The Planning Inspectorate

Our Ref: TR020001

Application by London Luton Airport Limited for an Order granting Development Consent for the proposed London Luton Airport Expansion Project

Request for further information and written comments

Table 4.1. Summary of effects during construction and operation on European Sites within 30km of the Proposed Development.

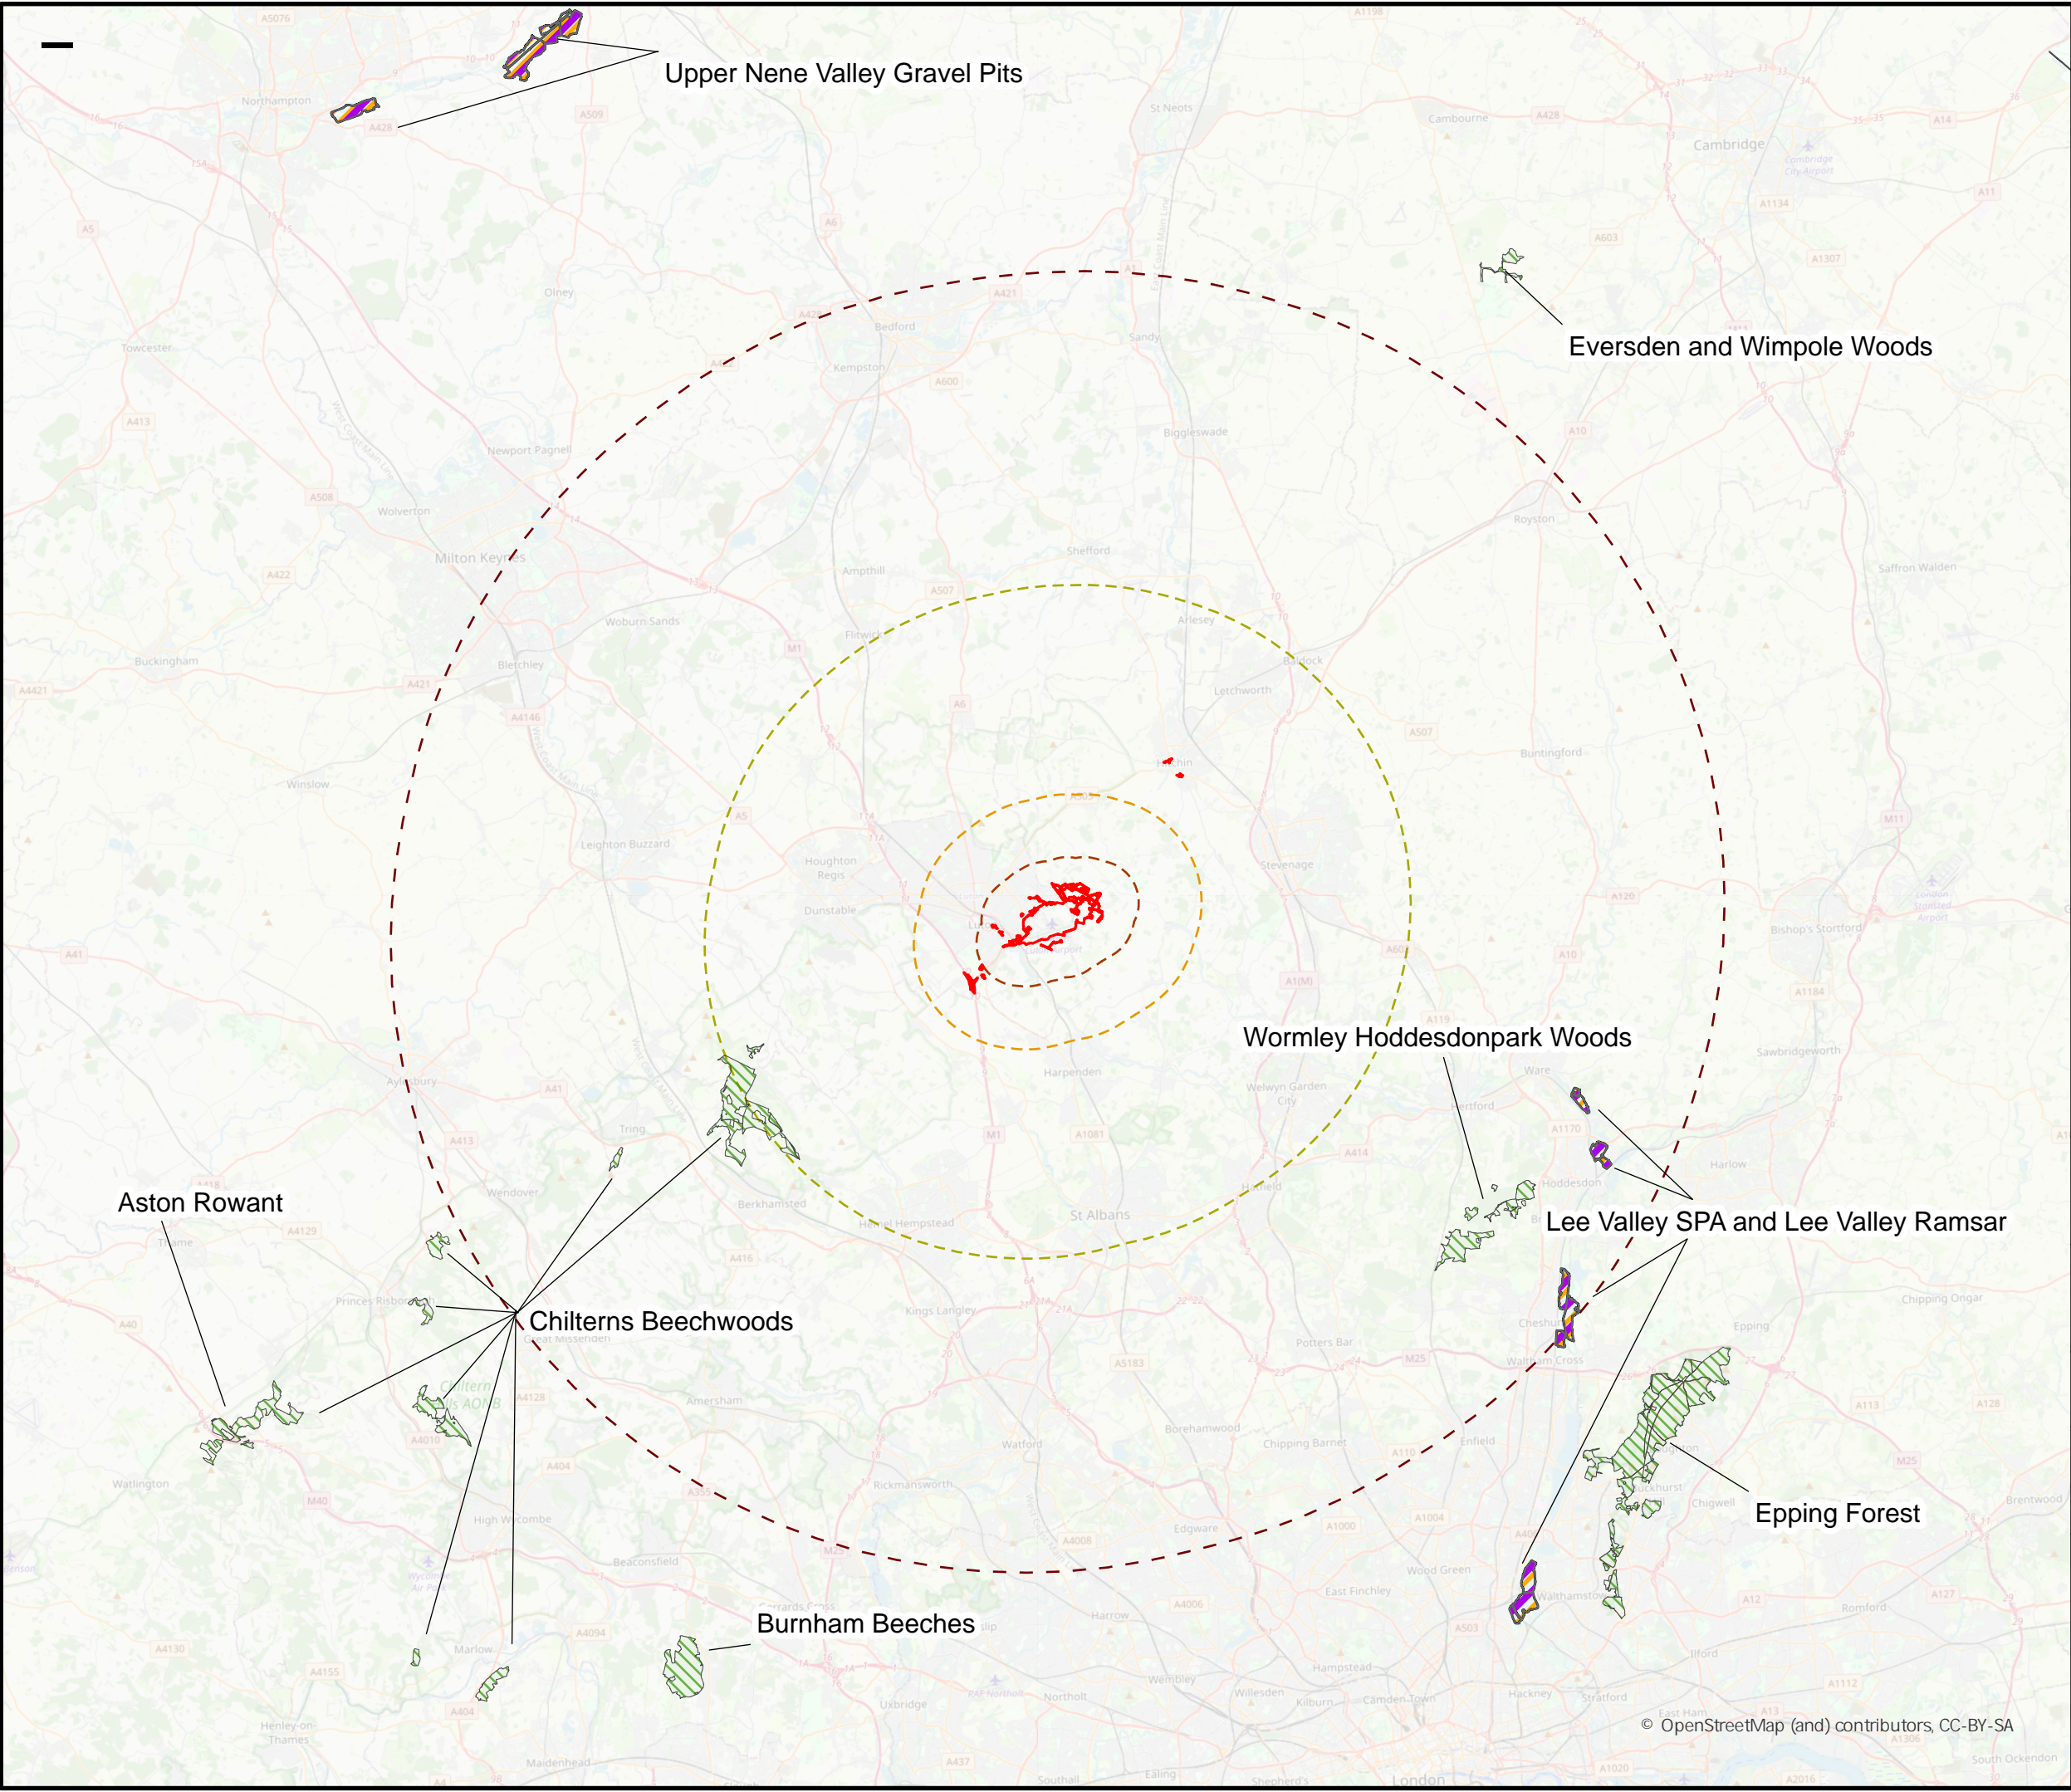
18. The ExA notes your conclusion that the Proposed Development is not likely to result in significant effects on the Chilterns Beechwoods Special Area of Conservation. Could you also provide a clear statement of your conclusion on the potential effects on the other European Sites referenced in the Habitats Regulation Assessment No Significant Effects Report' [Appendix 8.3, APP-171], including Lee Valley Special Protection Area and Ramsar site.
